**KIRKLEES METROPOLITAN COUNCIL
INVESTMENT & REGENERATION SERVICE**

Reference No:	2025/62/92309/E
Site Address:	39, Beckett Road, Dewsbury, WF13 2DD
Description:	Erection of extensions and alterations
Recommending Officer:	Jennifer Booth

DECISION - REFUSED

OFFICER REPORT

Drawing title Proposed Elevation

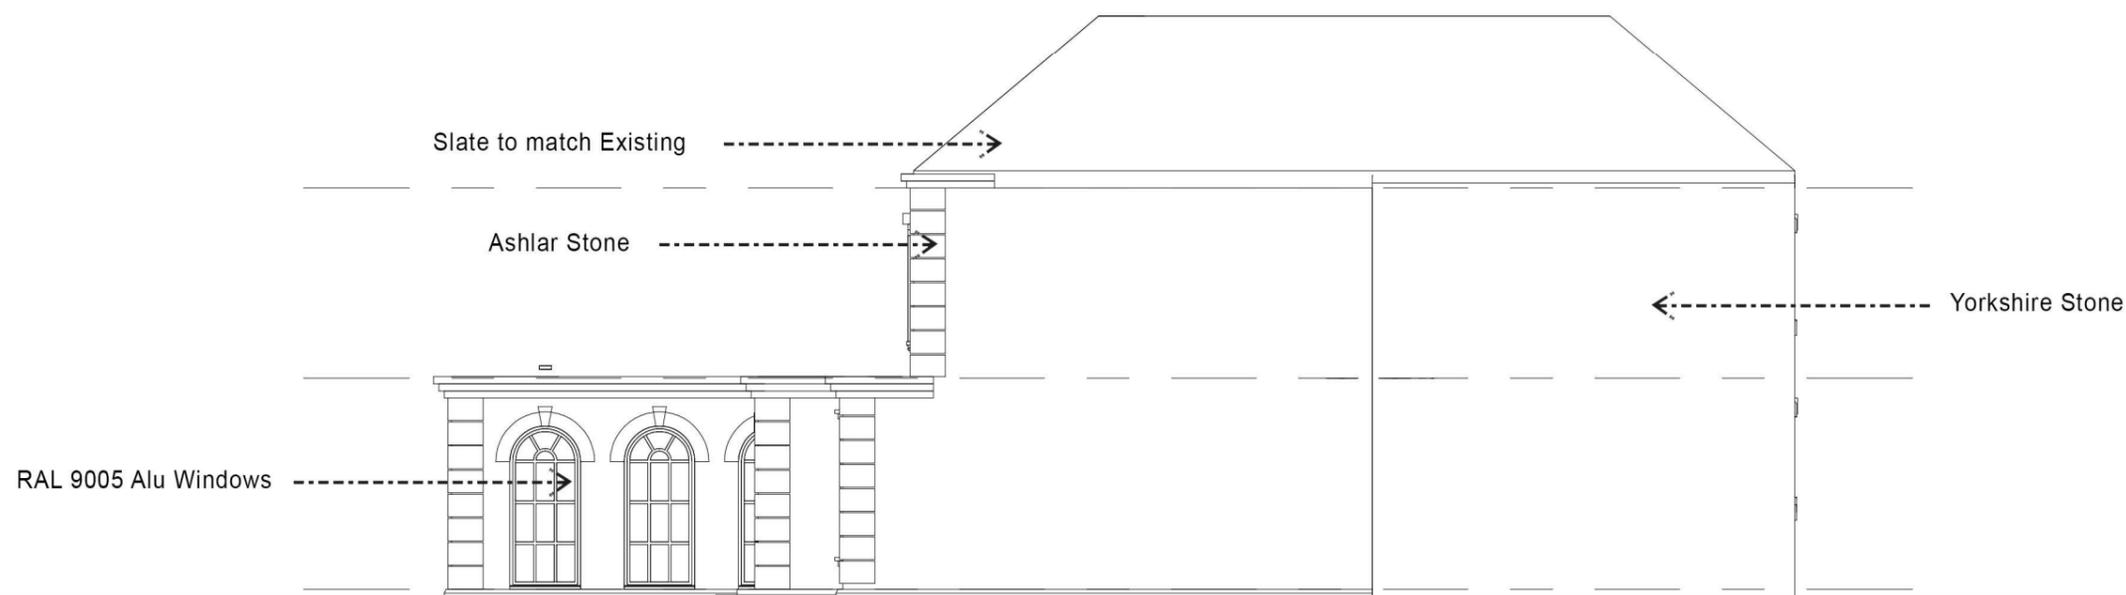
The proposed single and two-storey front extensions are of a significant and prominent scale which is not adequately mitigated by the dwelling's set-back position within the plot. As a result, the development would appear visually dominant within the street scene. The extensions are not subservient in scale or form, contrary to the guidance set out in paragraph 5.13 of the SPD, and their overall massing is considered excessive when viewed in relation to the host dwelling. The proposals would significantly alter the simple and legible form of the existing building through the introduction of additional bulk and detailing, resulting in an incongruous and over-developed appearance. Despite the varied character of the surrounding area, the scale and design of the extensions would fail to respect the established character of the dwelling and would cause harm to visual amenity, contrary to paragraph 5.14 of the SPD. The use of matching materials, including stone walling and tiled roofing, is insufficient to overcome the fundamental concerns relating to scale, dominance, and lack of subservience.

Having taken the above into account, the proposals would result in significant harm to the visual amenity of the host dwelling and the wider street scene. The development fails to comply with Policy LP24 of the Kirklees Local Plan, as the form, scale and layout of the extensions are excessive and visually dominant. Furthermore, the extensions would not constitute a subservient addition to the existing dwelling, instead appearing incongruous and out of keeping with its original form, contrary to criteria (a) and (c) of Policy LP24. The proposal is also in conflict with KDP 1 and KDP 2 of the House Extensions & Alterations SPD, which seek to ensure that extensions respect the scale, character and appearance of the host property. As such, the development would fail to achieve the aims of Chapter 12 of the National

- The design is not in keeping with the property or area – **Response:** *the design adds details which are out of context with the host property and the area.*

- The level of extension would not be subservient – **Response:** *the design and scale of extension to the front would not appear subservient to the host property.*

The proposed single and two-storey front extensions, by virtue of their scale, massing, and design, would appear visually dominant and fail to read as subordinate additions to the host dwelling. The extensions would result in an excessive and overdeveloped form, significantly altering the simple and character of the existing building and introducing incongruous bulk and detailing that would be prominent within the street scene. The development would therefore fail to respect the character and appearance of the host dwelling and would cause harm to visual amenity. To permit the proposals would be contrary to Policy LP24 of the Kirklees Local Plan, KDP1 & KDP2 of the House Extension & Alterations SPD and Chapter 12 of the National Planning Policy Framework.

Drawing title Proposed FF Plan

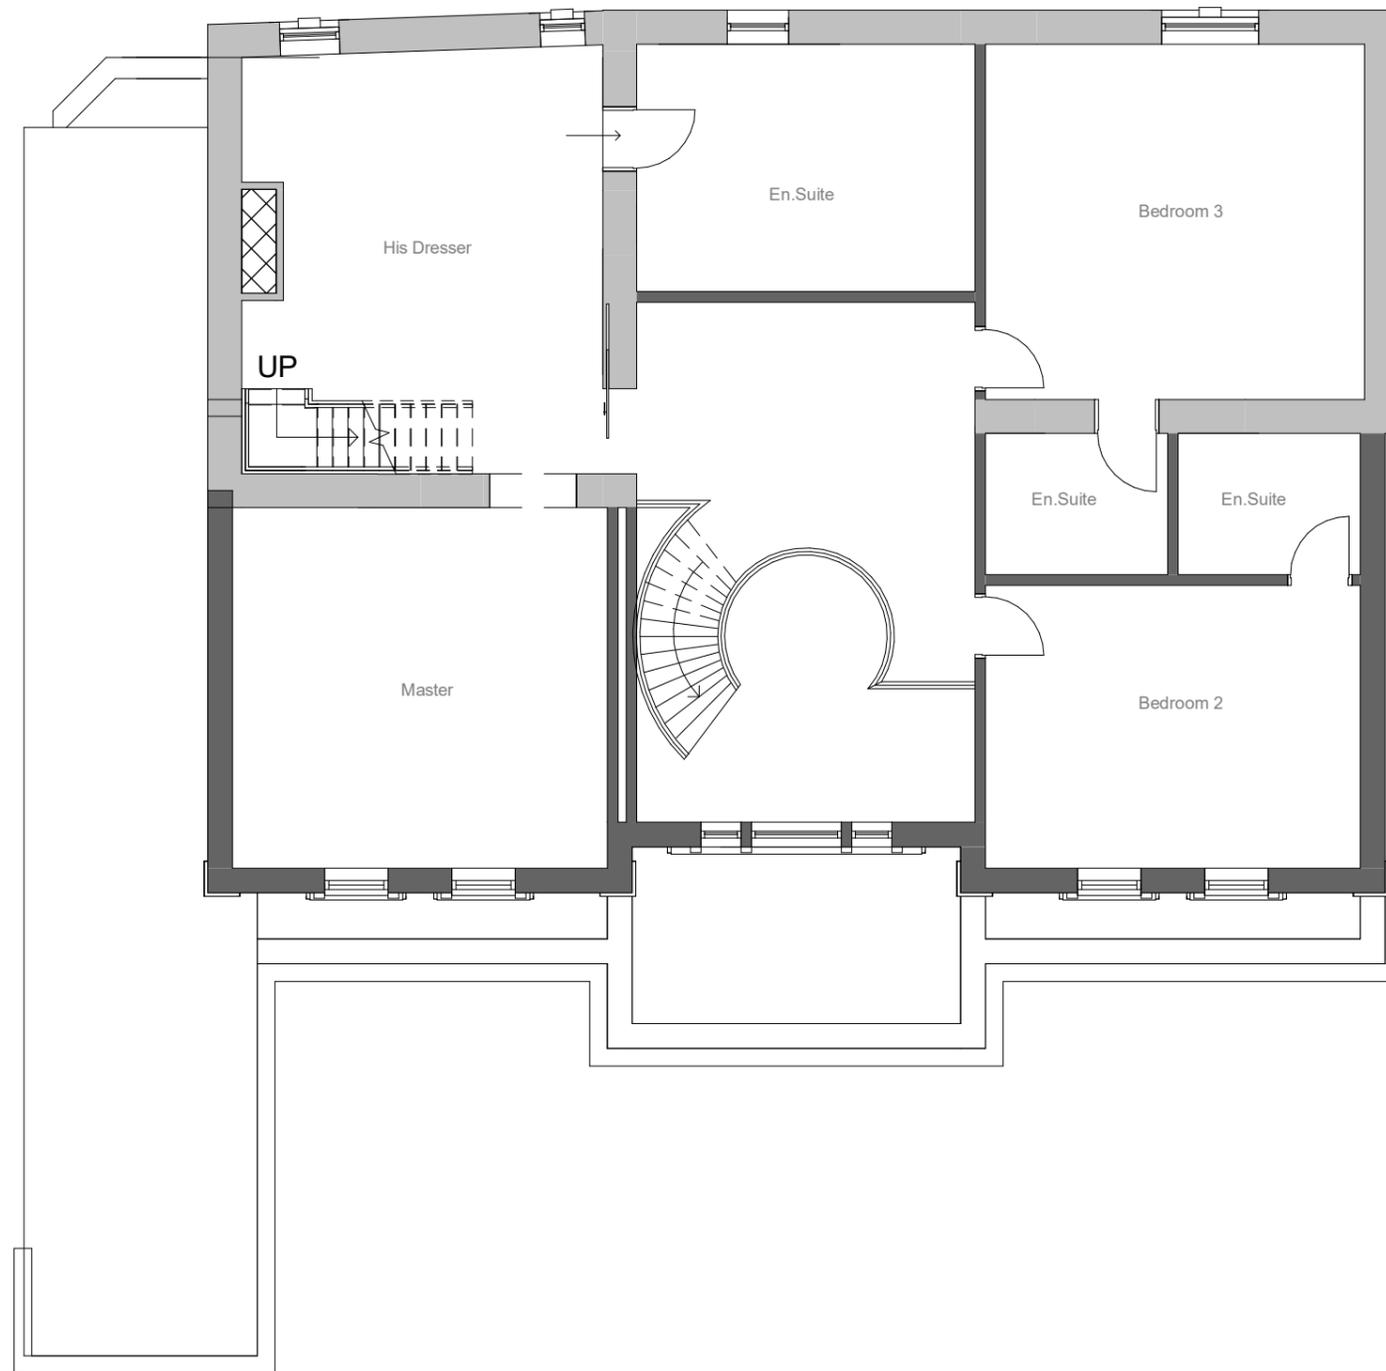
The ground floor would project between 5.8m and 7.4m in a stepped arrangement across the full width of the two storey house. There would be an additional single storey extension of the existing single storey of 5.5m. The first floor would be set back with projections of between 5.8m and 4.8m.
